DRBA

| APPLICATION NO. 06AA-00008 | PROJECT NO. 100 2277 |
| PROJECT NAME JOURNAL CENTER 2 | LOTS 354 |
| ONE STOP COMMENT FORM LOG | |

SITE PLAN

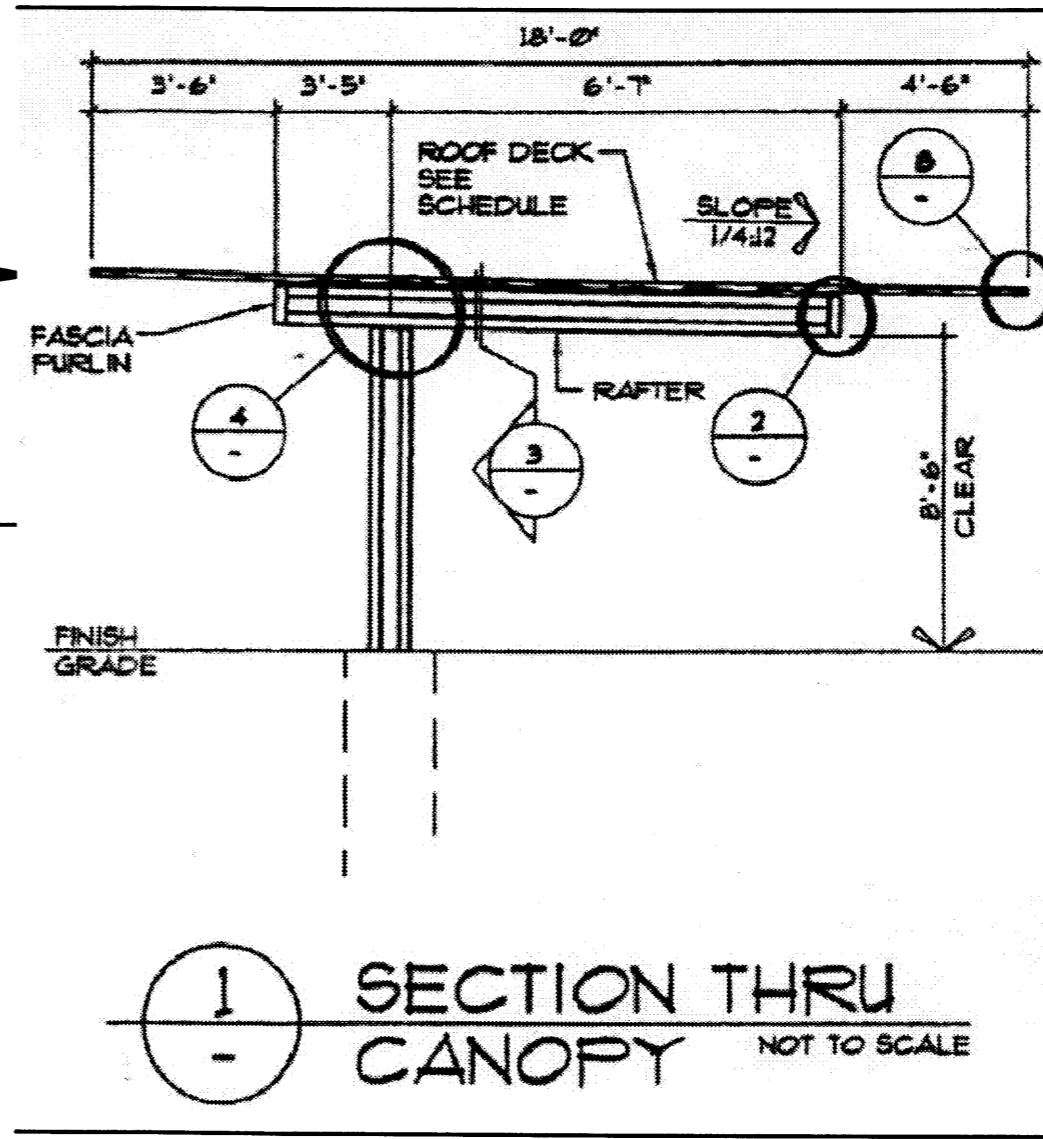
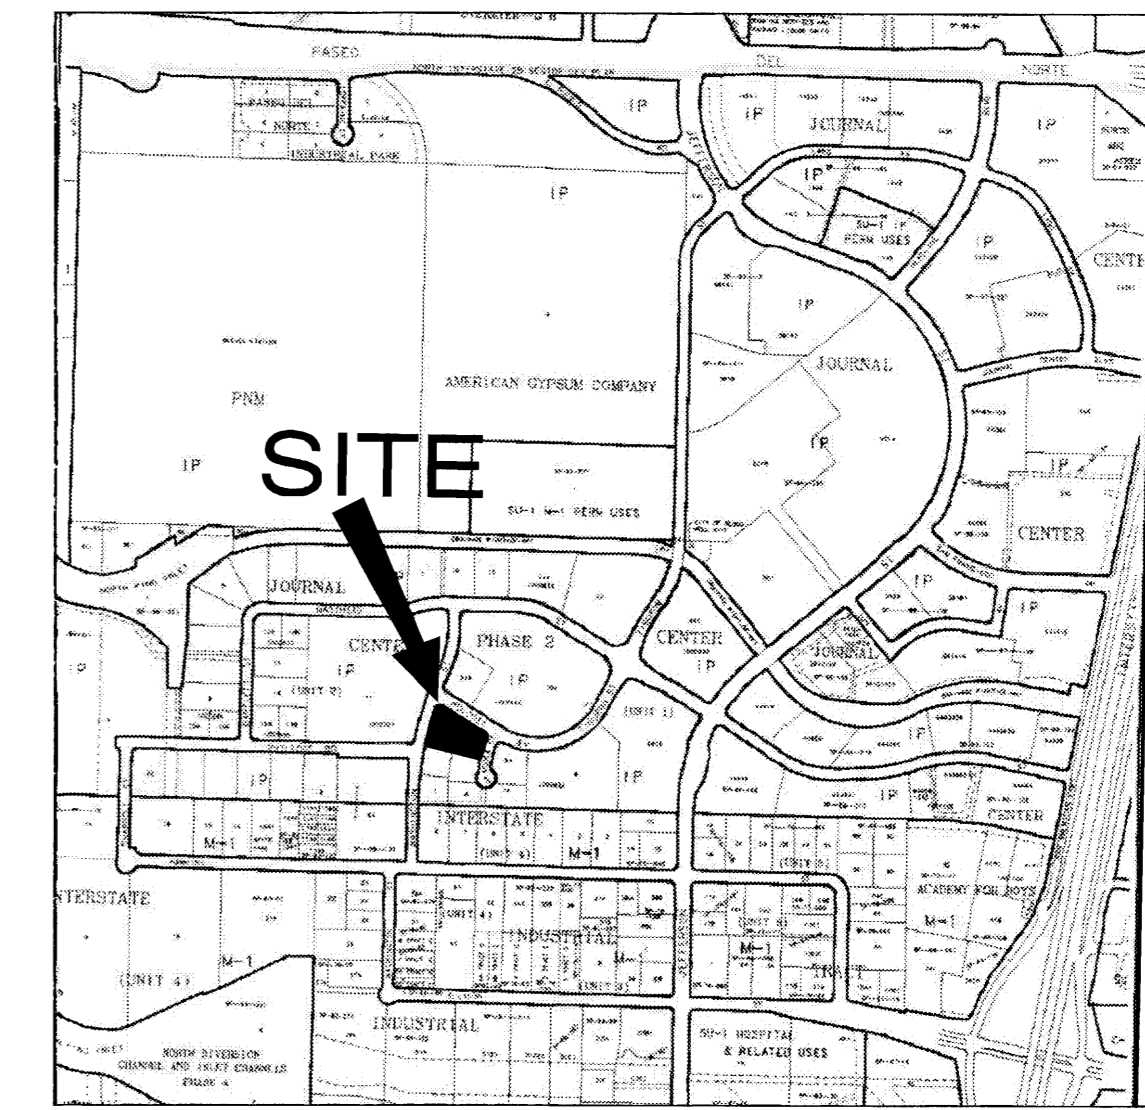
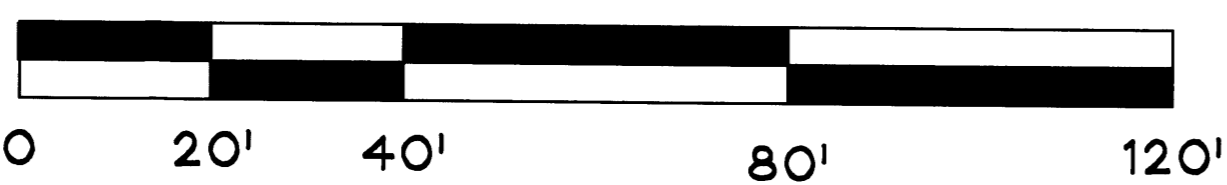
| <i>Canopy roof must drain to paved surface</i> | | |

| <i>No objection on the condition that the canopy's that don't block Refuse enclosed entrance & obstruct</i> | | |
